12th March 2021

Application Ref.: F/4/20/OUT

Proposal: Outline planning application (with all matters reserved except for access) for the development of up to 1,500 dwellings (Use Class C3), 60-bed care home (Use Class C2), up to 9,000 sqm. of employment floorspace (Use Classes B1), local centre of up to 2,350 sqm including up to 900 sqm retail/ commercial (Use Classes A1-A5) and 1,450 sqm community/ leisure floorspace (Use Classes D1-D2), land for a two-form entry primary school (Use Class D1), public open space, allotments, new sports pitches and associated facilities, drainage, parking and associated access, infrastructure, landscape, ancillary and site preparation works, including demolition of existing buildings and part removal of existing runway hardstanding.

Location: Land at Ford Airfield Ford

Figure 33: Outline Planning Application Parameter Plans - presented in detail on the following pages

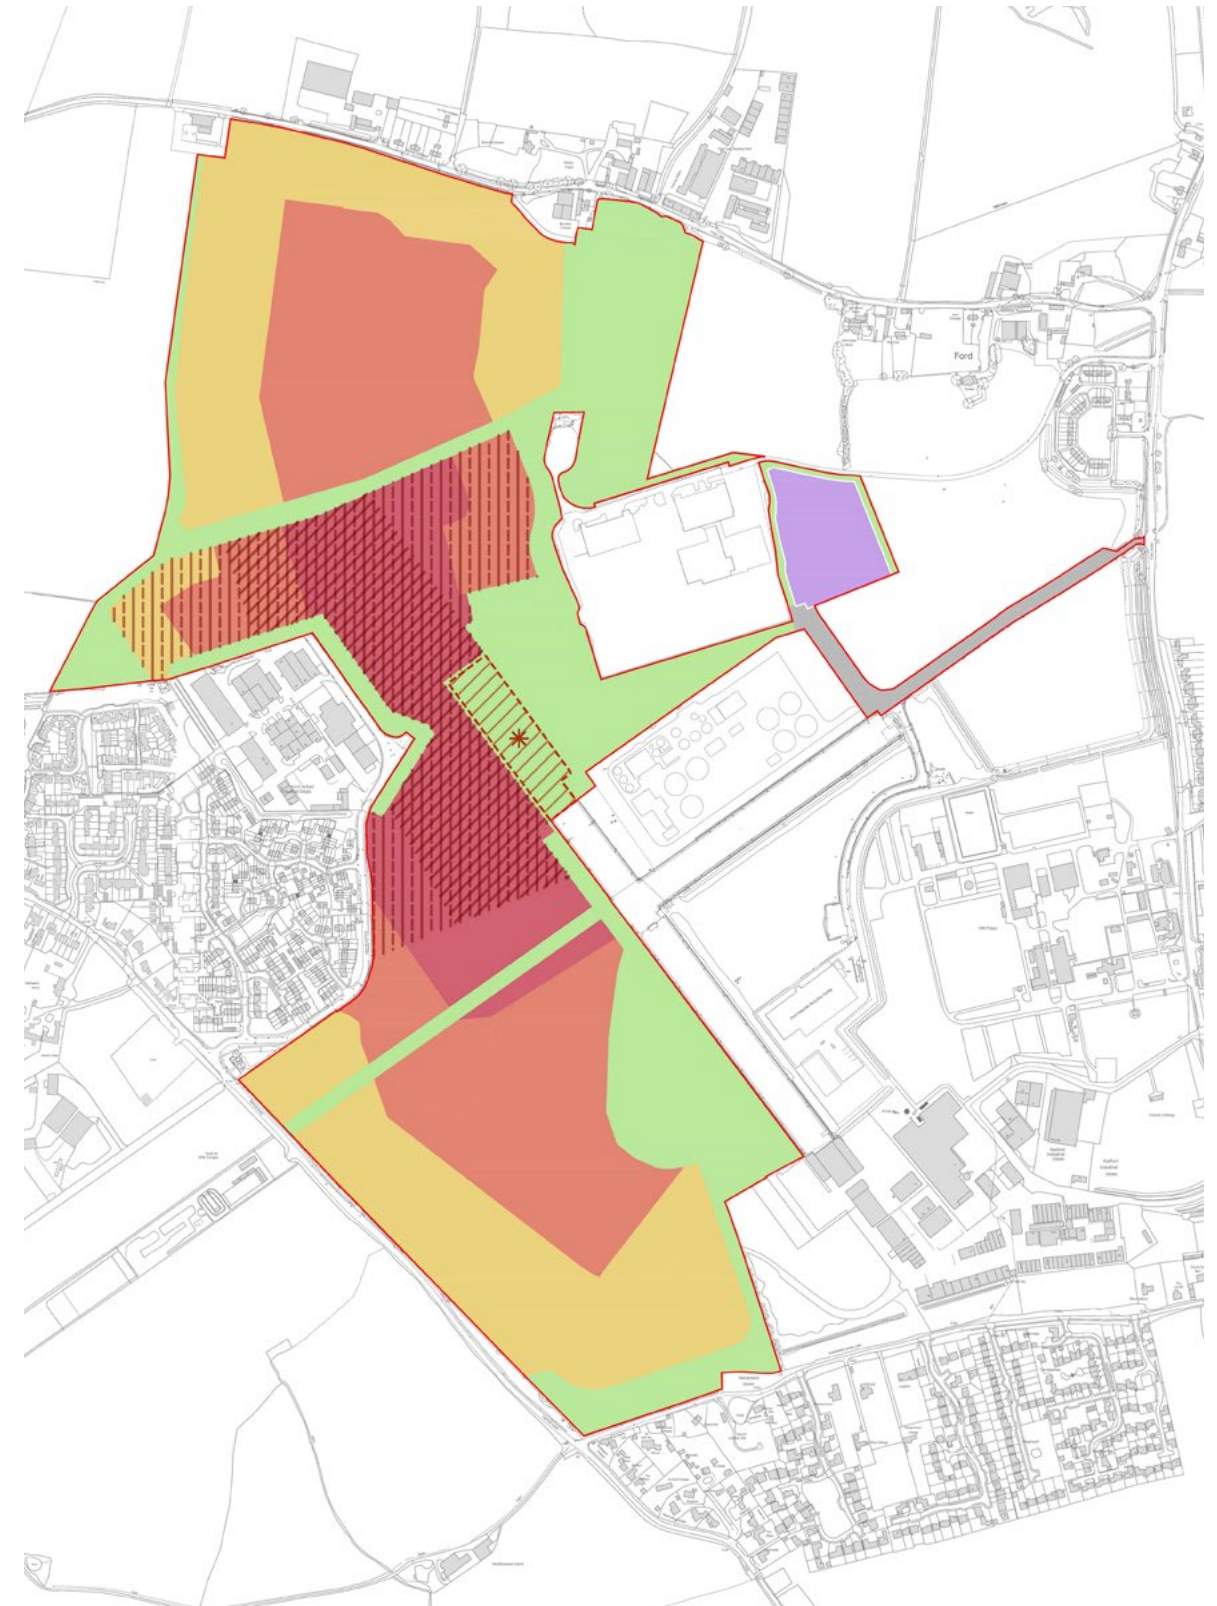
Notwithstanding the land use and density parameter plan (RG-M-123K), prior to commencement on site, a detailed noise mitigation scheme shall be submitted to and approved in writing by the LPA to ensure that all noise sensitive properties are protected and that current and future waste activities in the area are not prejudiced. The detailed noise mitigation scheme shall provide details of all noise sources in the area and the proposed mitigation relevant to each noise source. The mitigation measures to be considered by the mitigation scheme will include but shall not be limited to those referred to in Section 4 of the Waste Infrastructure Statement dated February 2021, namely:

- *Appropriate buffer zones between noise sources and noise sensitive properties (e.g. residential, care home)*
- *Acoustic barriers in the form of acoustic fences and landscaped mounds*
- *Orientation of dwellings and gardens so that no habitable rooms are facing Ford Circular Technology Park*

The proposed layout of any noise sensitive properties must demonstrate how 10dB of noise reduction as demonstrated in the memorandum note of 24 Acoustics dated 24 November 2020 (between the noise levels incident at the dwelling façades directly facing Ford Circular Technology Park, and the noise levels at incident at the façades of the habitable windows) will be achieved across the development, to ensure that future occupiers are not impacted by the current and future waste activities at Ford Circular Technology Park.

Figure 3: Potential noise sensitive areas

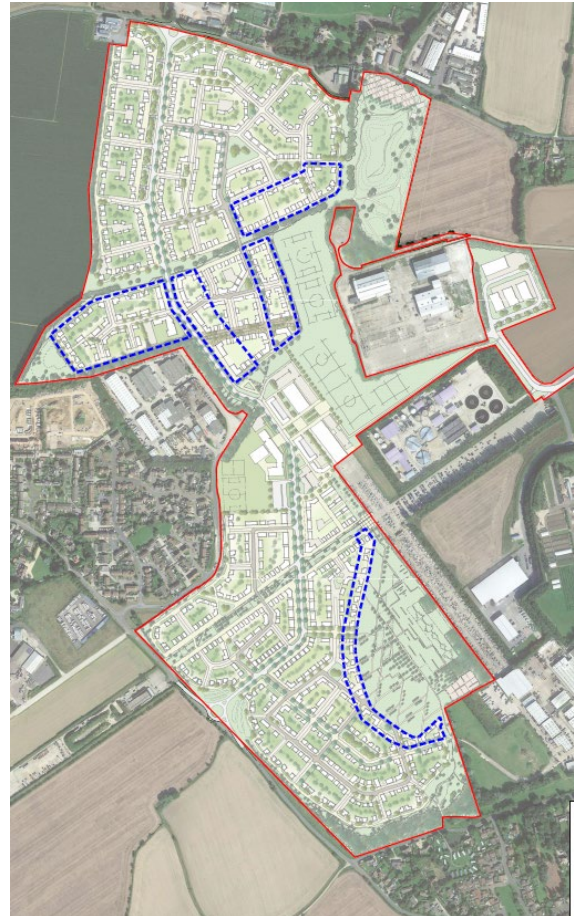
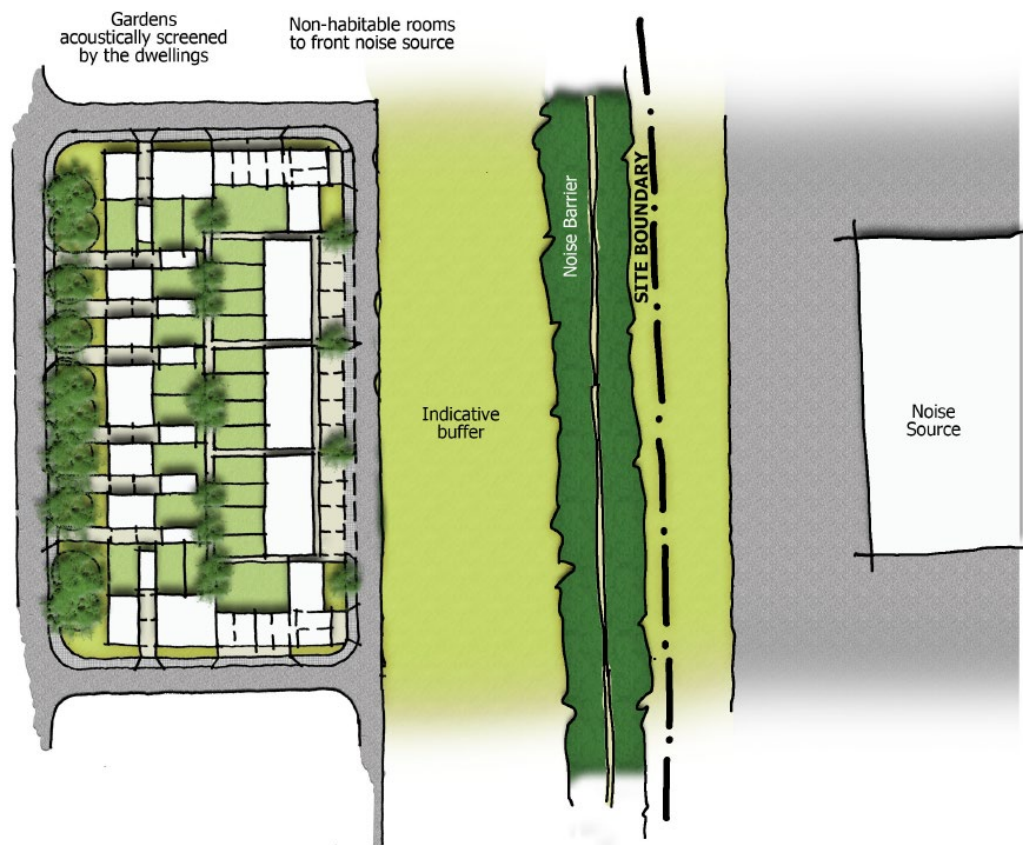
As set out within our previous representations, we continue to have major doubts regarding the suitability and deliverability of the noise mitigation measures relied upon by the Applicants. In addition to this, it is considered that the proposed condition offered by the Applicant in Section 4.9 of the Waste Infrastructure Statement is not sufficiently precise. We would therefore suggest the following wording as an alternative:
